WEST SUSSEX COUNTY COUNCIL CONSULTATION

TO:	Arun District Council FAO:Amber Willard
FROM:	WSCC - Highways Authority
DATE:	13 November 2020
LOCATION:	35 Kings Drive Bognor Regis PO21 4PZ
SUBJECT:	P/100/20/HH Single storey rear extension, first floor front extension and driveway with dropped kerb.
DATE OF SITE VISIT:	n/a
RECOMMENDATION:	Advice
S106 CONTRIBUTION TOTAL:	n/a

Proposed Site Plan

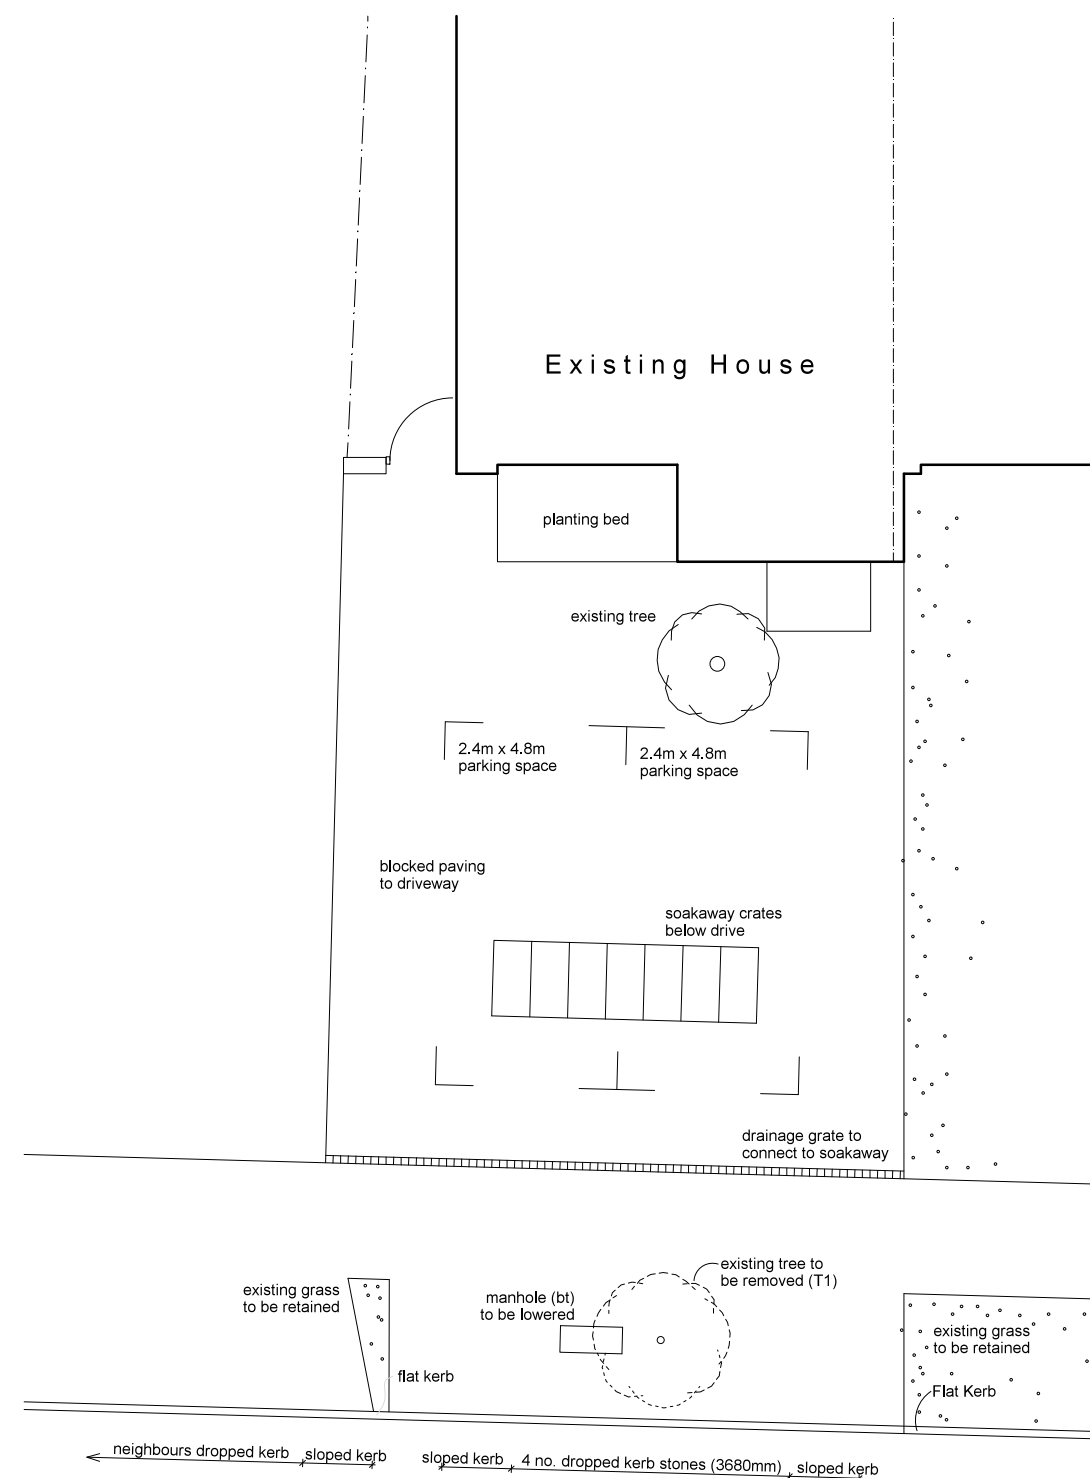
The application includes construction of vehicle crossover (VCO) onto Highland Road. The proposed access, as annotated on the site plan will be approximately 5.52m wide. Any access works onto the public highway must be constructed under a licence obtained from WSCC Highways, to a specification agreed with them. I note the presence of a highways tree fronting the property.

'The licence will most likely be refused as we don't take kindly to removal of trees. If the applicant agrees to fund a new tree elsewhere in the street (subject to consultation for a suitable location) then we might be agreeable but that will need someone to look into it in more detail than I can provide right now.'

From a highway safety perspective, the LHA cannot justify an objection as there are no overriding safety concerns, however the Area Office have confirmed that may not grant a licence due to their policy.

The applicant is advised to communicate with WSCC Highways regarding the proposal. Their contact details are included below.

The use of the access shall not commence until such time as the vehicular access serving the development has been constructed in accordance with the details shown on the site plan.
